DRB CASE ACTION LOG - BLUE SHEET

Project #: 1009053 Application #: 11DRB-70334
Project Name: Ridgecrest Addn
Agent: Wayjohn Surveying Phone #:

11. **Project# 1009053**
11DRB-70334 MINOR - PRELIMINARY/
FINAL PLAT APPROVAL
WAYJOHN SURVEYING INC agent(s) for RONALD , BERNADINE, JASON PAIZ request(s) the above action(s) for all or a portion of Lot(s) 19-24, Block(s) 39, **RIDGECREST ADDITION** zoned R-3, located on ON GIBSON BETWEEN JACKSON & TRUMAN containing approximately .9203 acre(s). (L-717) **THE PRELIMINARY/FINAL PLAT WAS APPROVED WITH FINAL SIGN OFF DELEGATED TO PLANNING FOR 30 FT. RADIUS.**

PLAT OF
LOT 24-A, BLOCK 39
RIDGECREST ADDITION

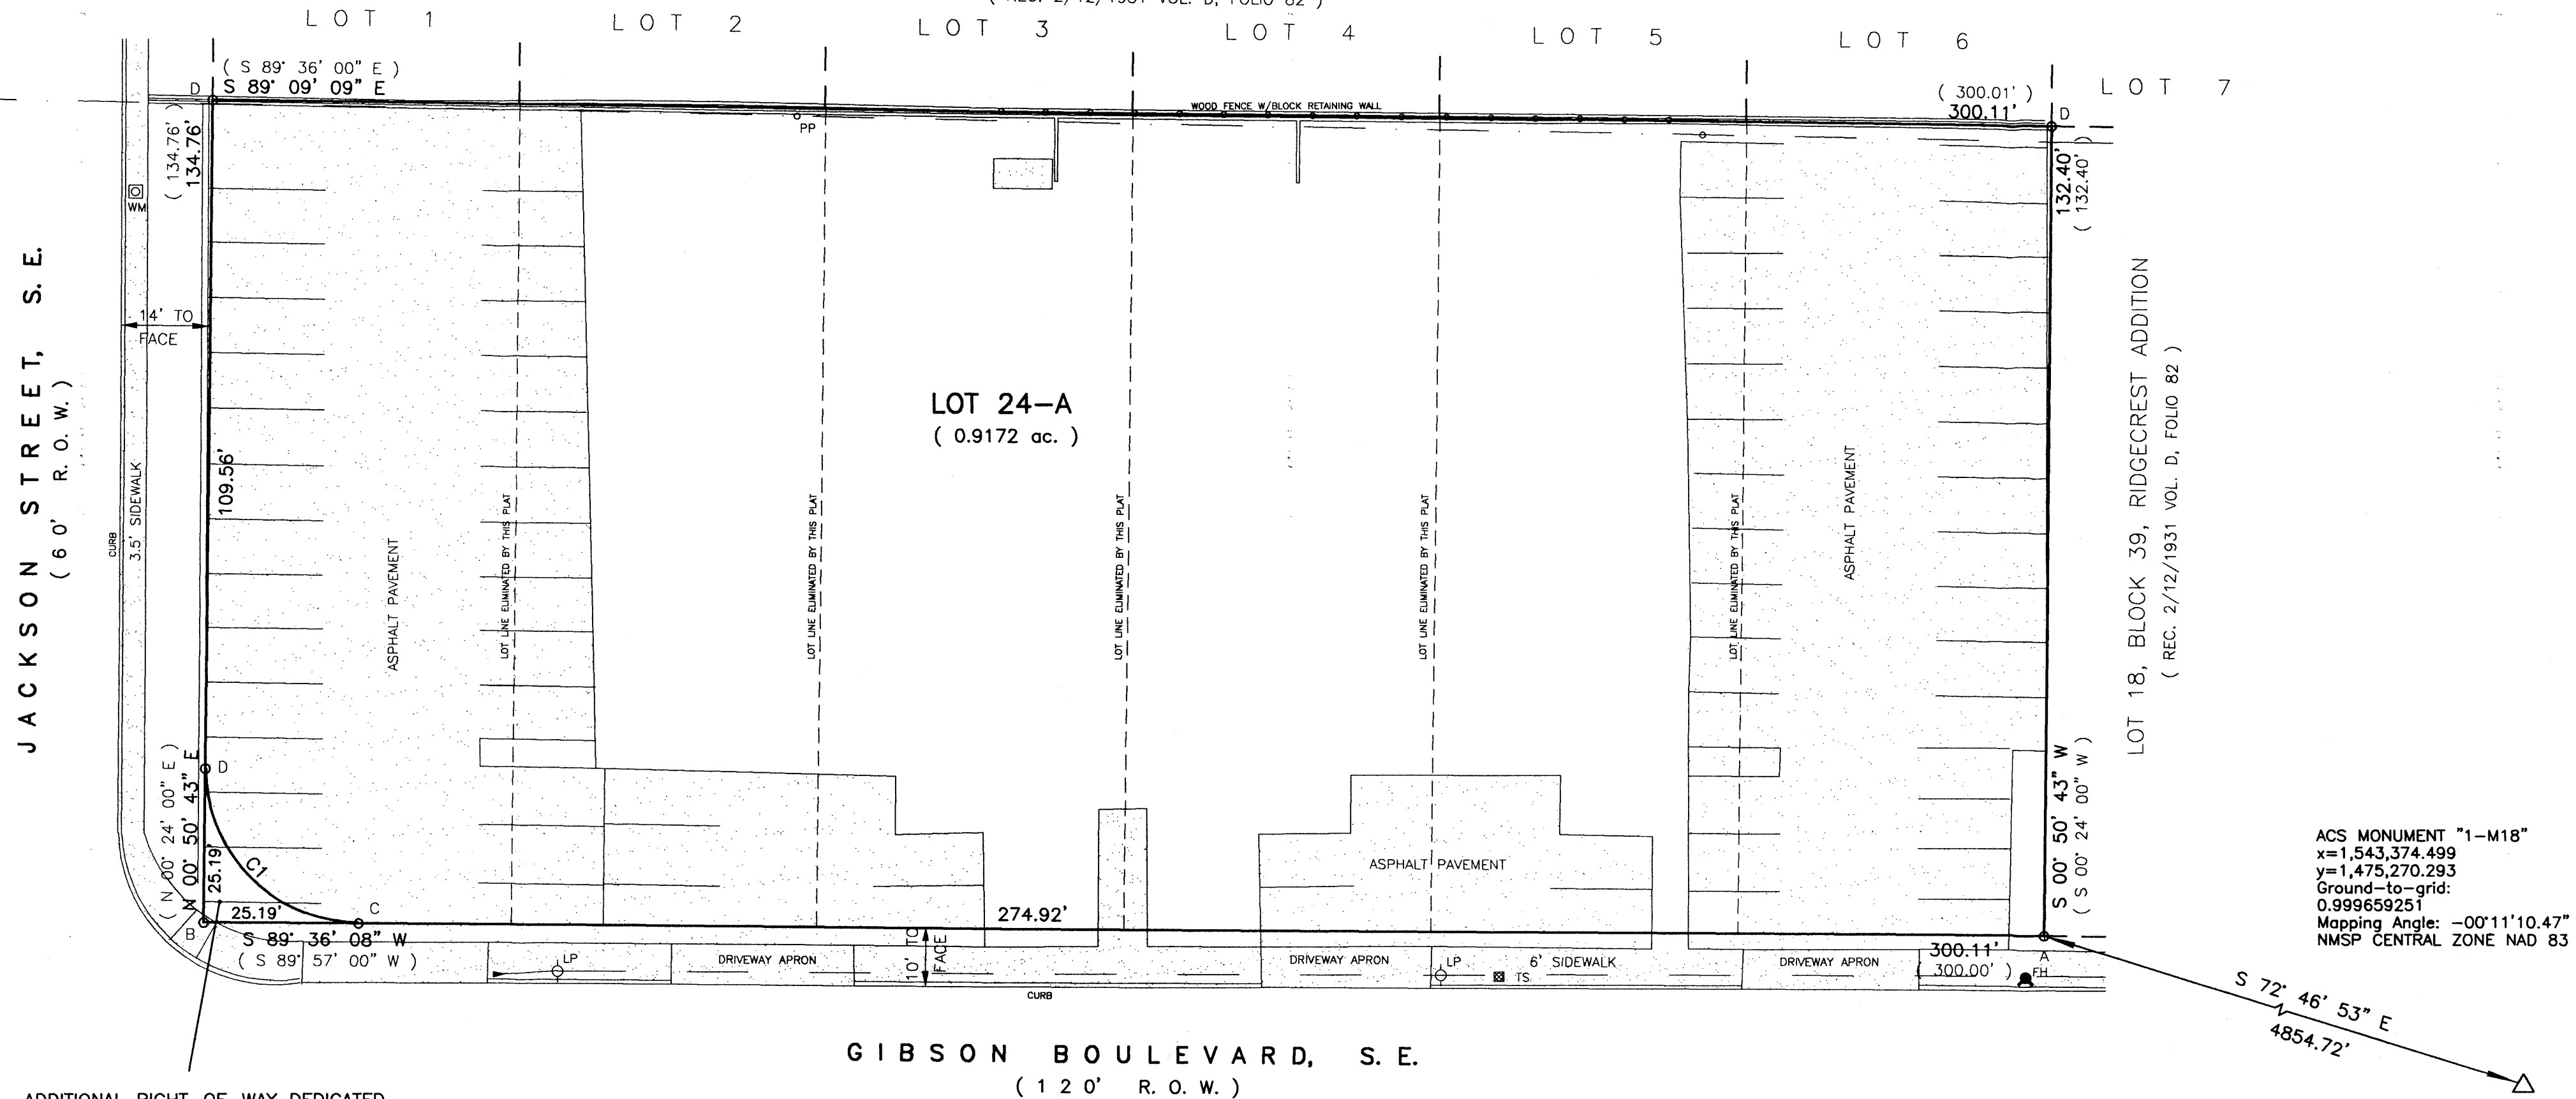
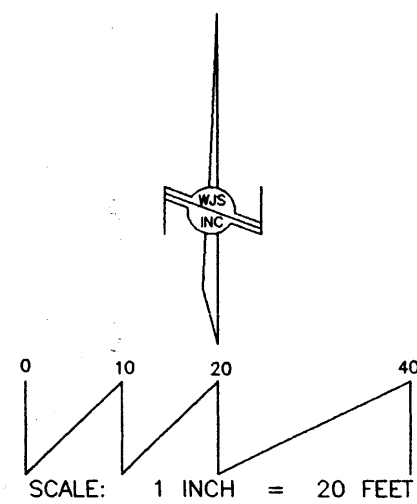
PLANNING (Last to sign): 30' r dedication

PLANNING (Last to sign): 30' 5' dedication
